**MAJOR PROJECT ASSESSMENT:  
Mixed Use Residential, Retail and  
Commercial Development  
330 Church Street, Parramatta  
(MP 10\_0171)**

Director-General's  
Environmental Assessment Report  
Section 75I of the  
*Environmental Planning and Assessment Act 1979*

October 2012

01 PLAN - PARKING LEVEL 04
1:200 @ A1

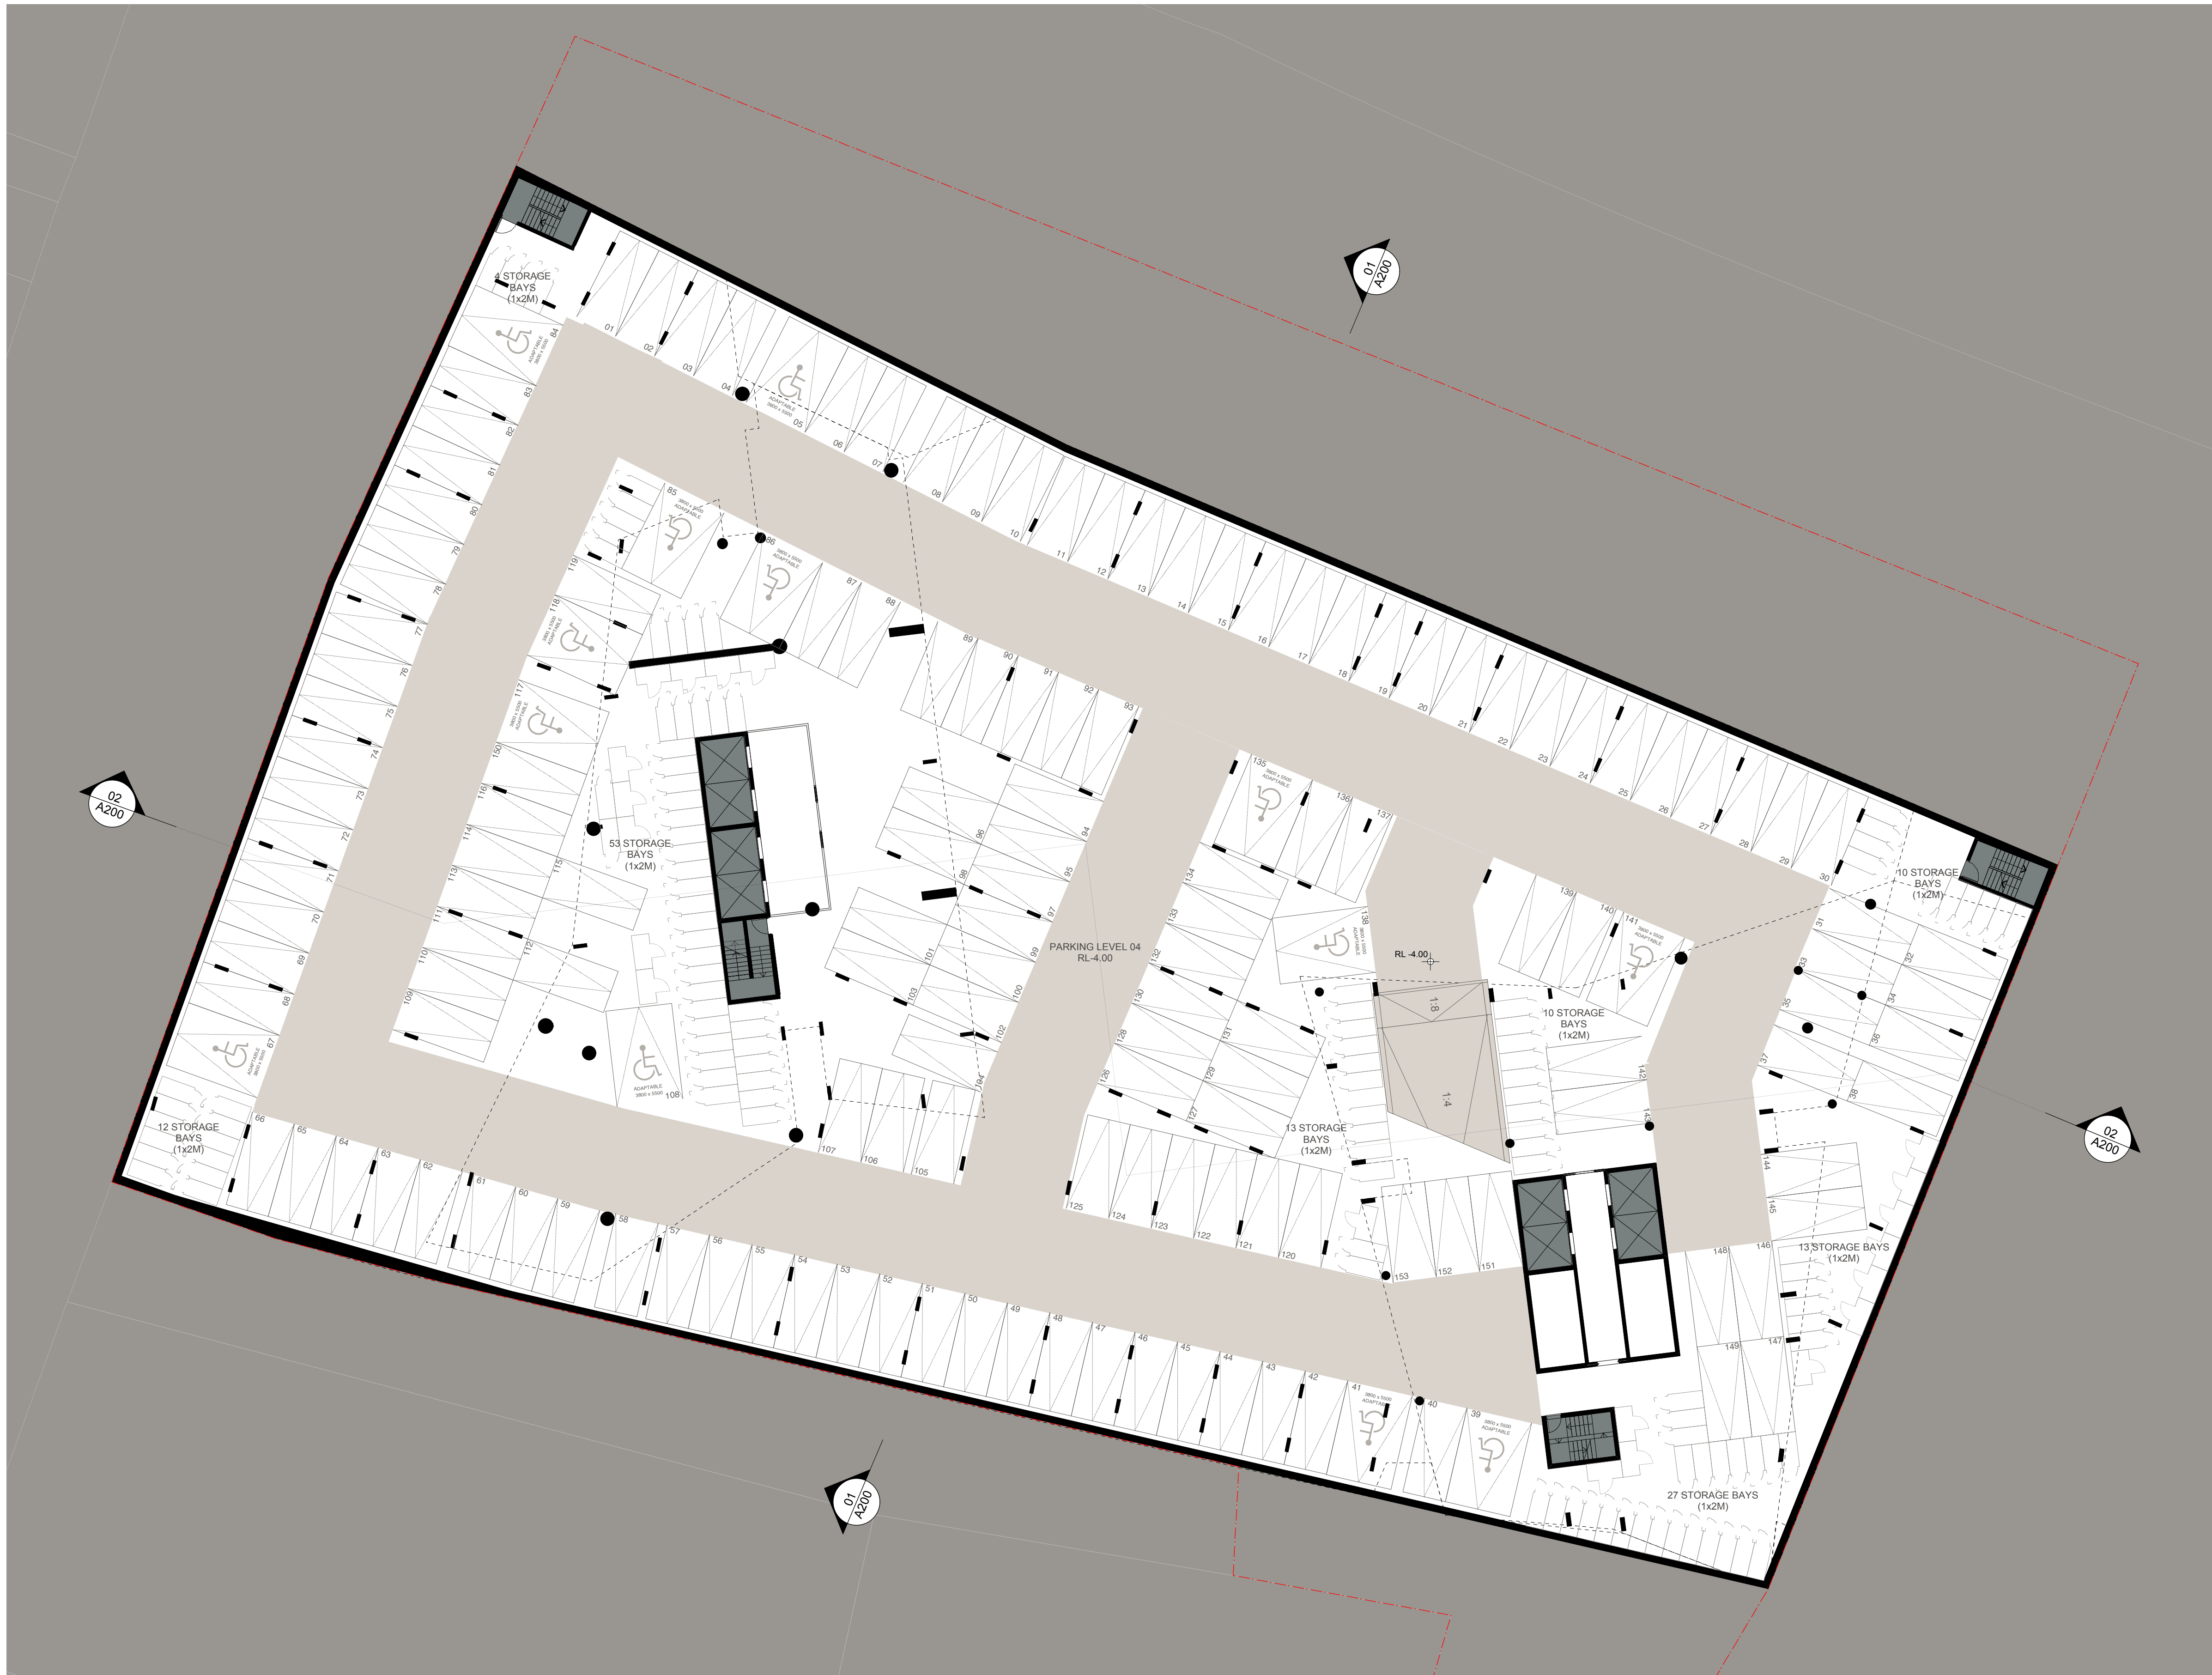
- Stacked car parking spaces should not be used by multiple building tenants or building occupants. To manage this issue a condition should be imposed to allocate stacked parking spaces to specific tenants.
- The disabled/adaptable parking spaces within basement levels 2 to 4 do not comply with AS 2890.6-2009.

The department notes that the basement car park plans have been revised to specify that all stacked spaces can not be used by multiple building owners or tenants.
